From: Andrew Wood
Sent: 26 February 2019 17:42
To: Planning.Responses
Subject: FW: Planning Application FG/220/18/PL : Land adjacent to Elm Lodge, Tamarisk Way, Ferring, West Sussex BN12 5ER

From: Katherine Jenkins [REDACTED]
Sent: 22 February 2019 12:27
To: Laura Gibbons
Cc: Andrew Wood
Subject: Re: Planning Application FG/220/18/PL : Land adjacent to Elm Lodge, Tamarisk Way, Ferring, West Sussex BN12 5ER

In order for me to remove my objection I am going to need some further information to be supplied:

Drawing Title **PROPOSED POND ACCESS
PLAN**

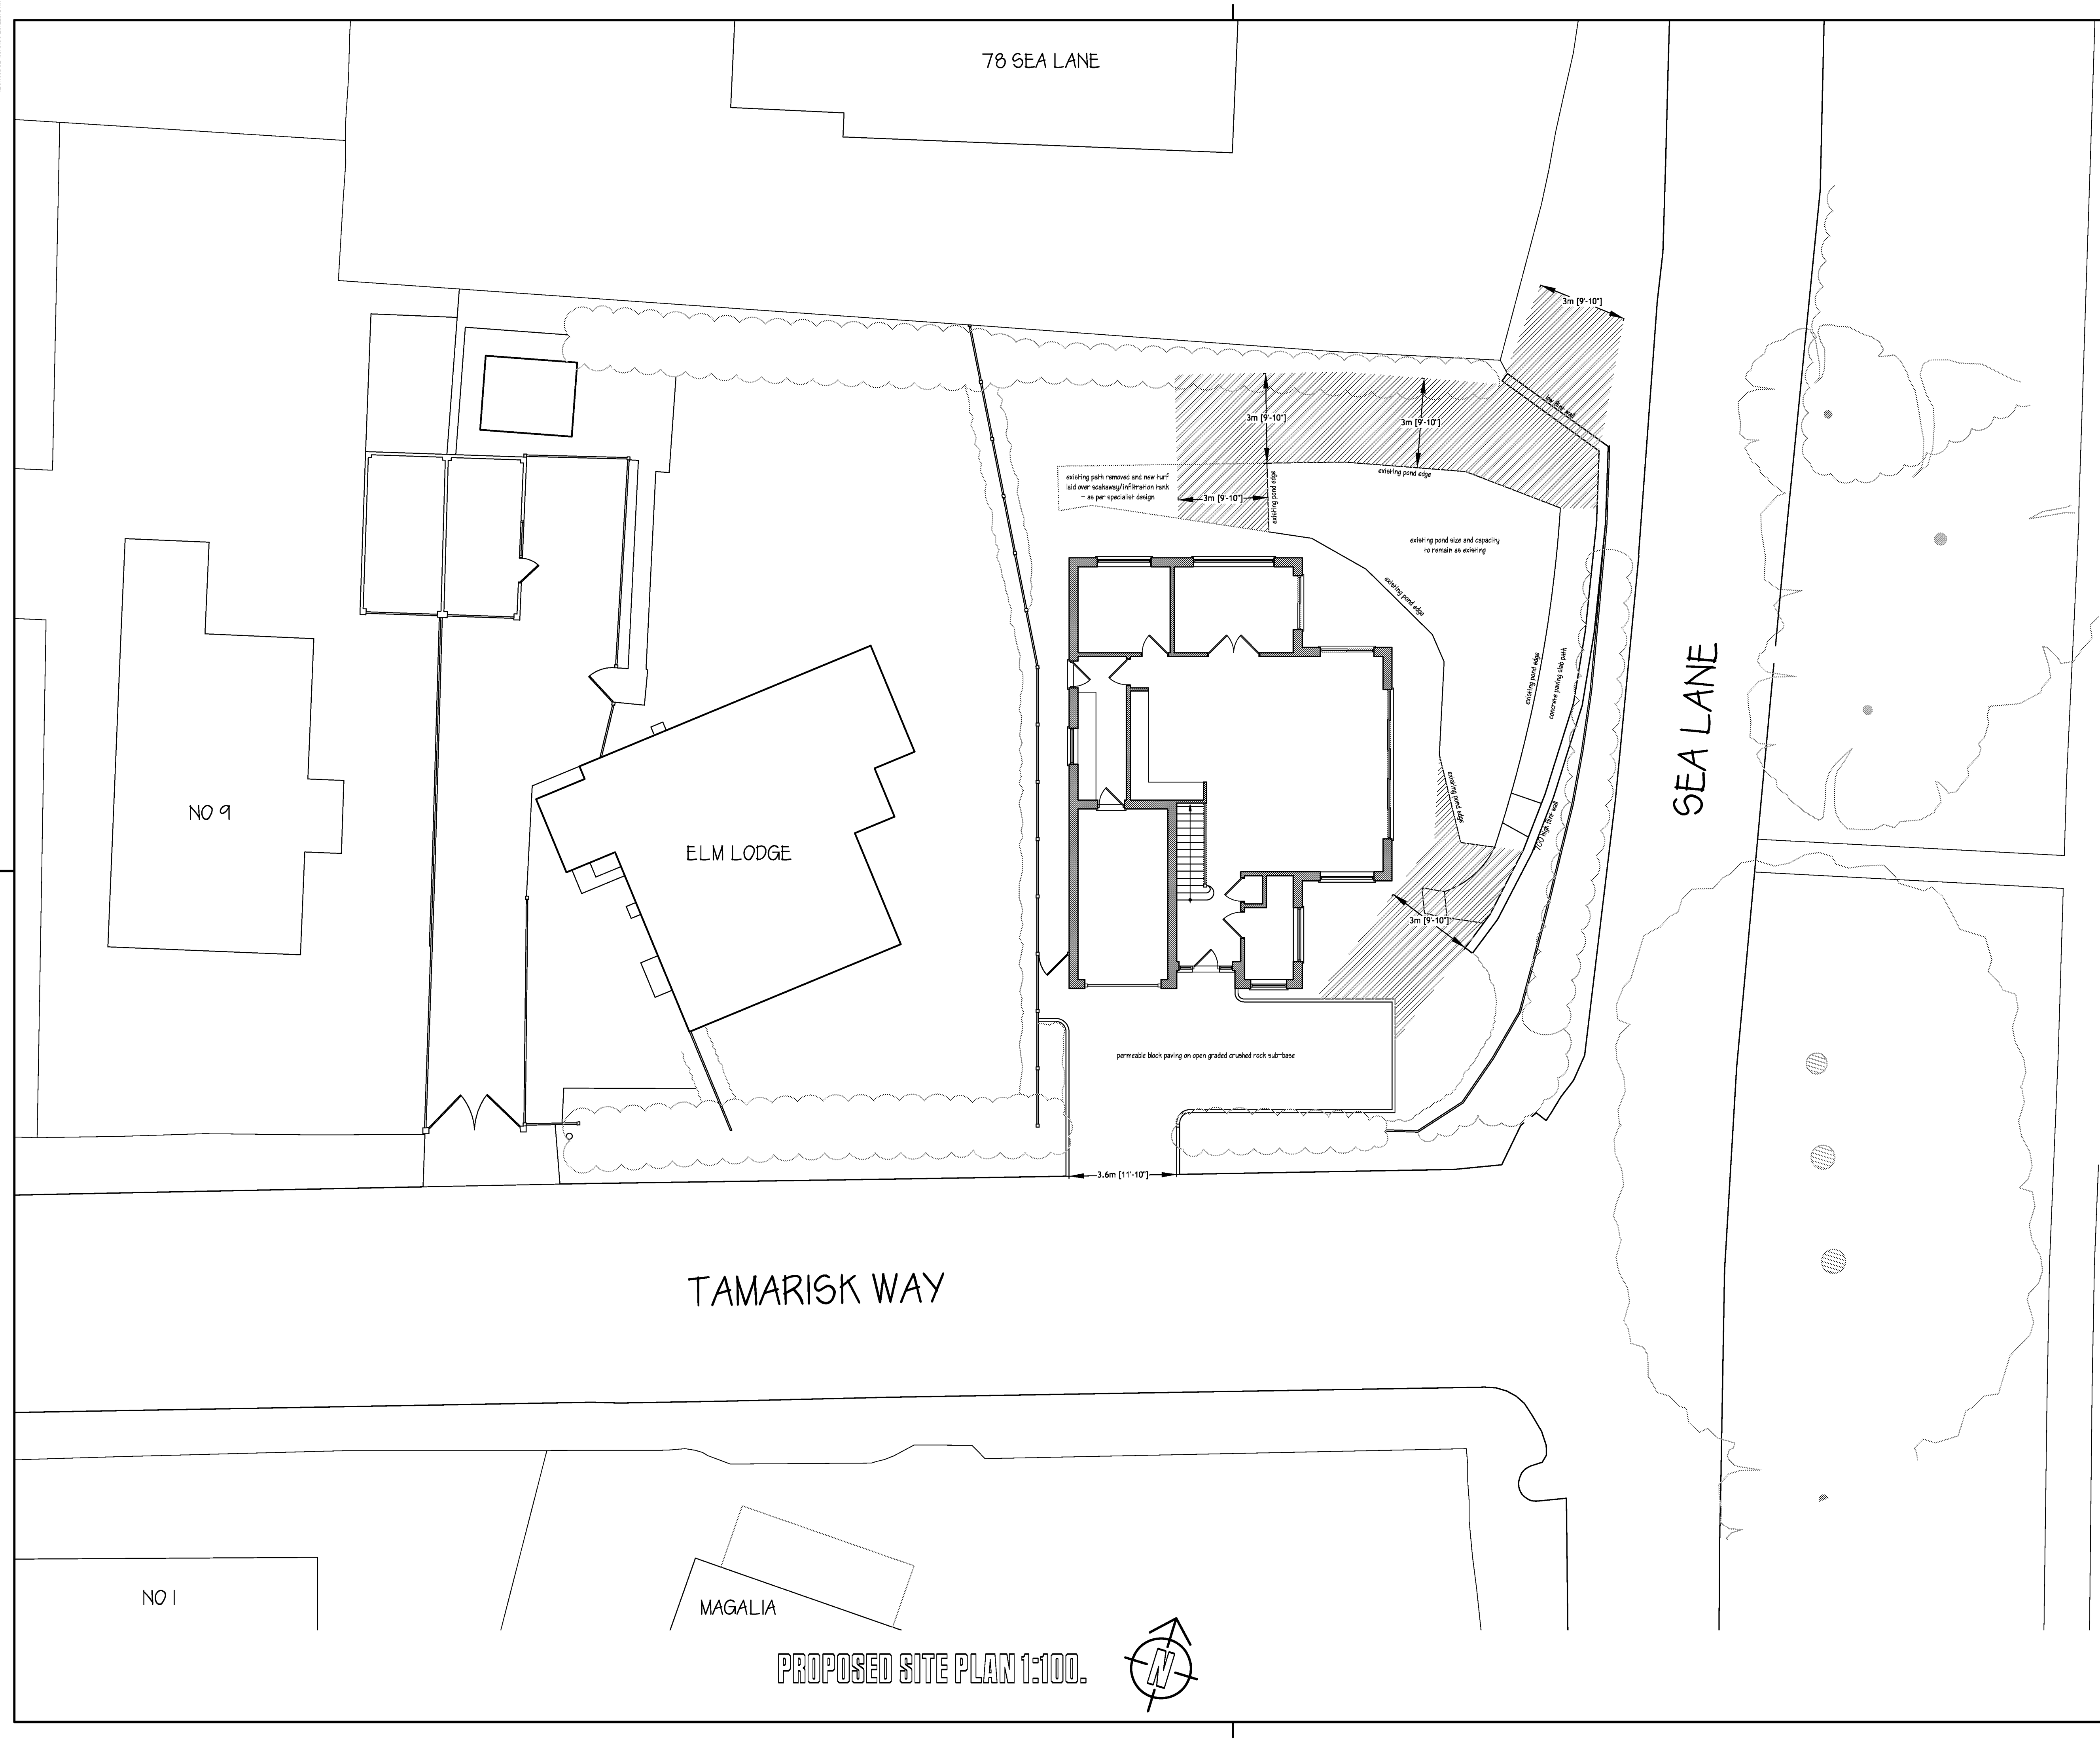
1. Please identify whether a pipe exists at the western extent of the pond. This will impact upon if I believe there is a likelihood you will have sufficient space for surface water drainage. The soakaway that you are currently proposing is located directly on top of the suspected pipe location. We will be able to identify the location of any potential pipe as part of a pre-commencement condition. We agreed that we could also submit details of proposed soakaway locations as part of the pre-commencement conditions relating to surface water drainage, once potential for soakaways had been adequately assessed, calculated and positioned by a civil engineer. It is likely the 100mm diameter soakaway pipes would be at a higher level if crossing over any existing pipe from the pond, therefore may not impact any existing pipe, although we would ensure this is checked by a civil engineer and approved by ADC as part of the pre-commencement condition. My concern is that there may not be sufficient area within the site to drain the new impermeable areas. I acknowledge your point regarding crossing over of pipes, however there is then no real room to get 5m from your building and 2.5m from the property boundary to site a soakaway which will likely be quite large in plan area.

2. I am not keen to see the building go up to within 0.8m of the pond. Access and erosion are both a concern. I would therefore be keen to see the building layout revised to provide more easement. As shown on the proposed indicative part foundation section detail, short bore piles would be positioned a minimum of 3m from any edge of the pond, reducing the risk of erosion by eliminating trench foundations. Given a specialist would be designing the reinforcement/camp shedding for the existing edge of the pond (again, to be agreed with ADC by condition prior to commencement), this would ensure there will be no erosion. Given the building would only be cantilevered at one point within 0.8m of the pond, there is still a large area of access around the east and all other parts of the pond. We note that ADC has never had to access the pond to carry out any maintenance works to date, therefore query why there is such an onerous requirement for access now. We also note that ADC cannot currently access the pond with plant, since we have gates to the property and a further gate at the rear which would obstruct machinery from accessing our garden to carry out any maintenance works at all. ADC would have greater access to the pond as a result of the proposal, given there would be no obstruction when entering from the driveway. ADC Bylaws state that "Riparian Owners are responsible for maintaining the watercourse and any associated structures (i.e. headwalls, screen, weir etc.) and primarily to keep them free of any obstructions that may impede flow in the watercourse". There will be no obstructions which impede the flow in the watercourse, as demonstrated. We can easily complete any pond works to ensure it is upgraded from its current state (which has not been identified as obstructed or badly maintained by ADC to date) before commencement of any building works on site. The bylaws state that "Arun District Council may decide to exercise the permissive powers if it is approached by property owners affected by badly maintained or obstructed watercourses and they have been unable to get a 'riparian owner' to carry out necessary works. In the first instance, Arun District Council will try to resolve the problem informally by explaining 'riparian ownership' responsibilities and agreeing the work that is required to the watercourse to rectify the problem. If this approach is unsuccessful, Arun District Council may require and enforce 'riparian owners' to carry out works using powers under S25 of the Land Drainage Act 1991 where the flow of water is impeded and the condition needs to be remedied." Given we as riparian owners will be able to access the pond from all sides to carry out any works in accordance with the bylaws, we do not understand why ADC would need access to our land, particularly from multiple different points given they cannot access it at all at present. It is the landowners (Riparian) responsibility to complete maintenance works, if we are informed of an impediment to flow we request landowners complete this maintenance. If they refuse to complete the work, we use our powers under S25, and this can be accompanied by forced entry through gates. The proposed layout will make it exceptionally difficult to

3. It is my belief that there is no way to get to the northern and western portions of the pond without tracking through the pond itself. This would mean that maintenance would have to be completed in the summer by the landowner when water levels are lower. This would then be within nesting bird season. I would much prefer an access to be provided around the pond. I note that you state the 1m wide path to the east could take plant but this plant would not be big enough. As explained above, we as landowners can continue to access the pond from all sides, with 3m to the West, North and South East. We cannot understand what plant would ever be required (given no plant has ever needed to access the pond before, and any plant necessary for carrying out works to the pond can have full access from all sides as part of the building works) that would ever be larger than a small digger, which can easily be maneuvered up the 1m side access to the west of site and around the rear. You are going to need a large digger to access the pond and clear it of vegetation and silt. The size of machine is dictated by the depths that excavation need to be carried out to, the size of plant that can fit along a 1m path would not be sufficient to carry out the excavation required. Ongoing maintenance will be required after construction is complete, this is when the proposed site layout in my opinion would prevent this work.

These show the existing pond to be retained in its entirety, with 3m access provided should Arun District Council ever need to access our property to maintain the pond. We hope these now alleviate your concerns regarding potential future access. We also note that the path to the east of the pond is also over 1m wide, which can currently comfortably accommodate a 1.5 ton digger to carry out any works. Given that there are multiple points of entry along the edge of the pond, any further work can be carried out from within the pond.
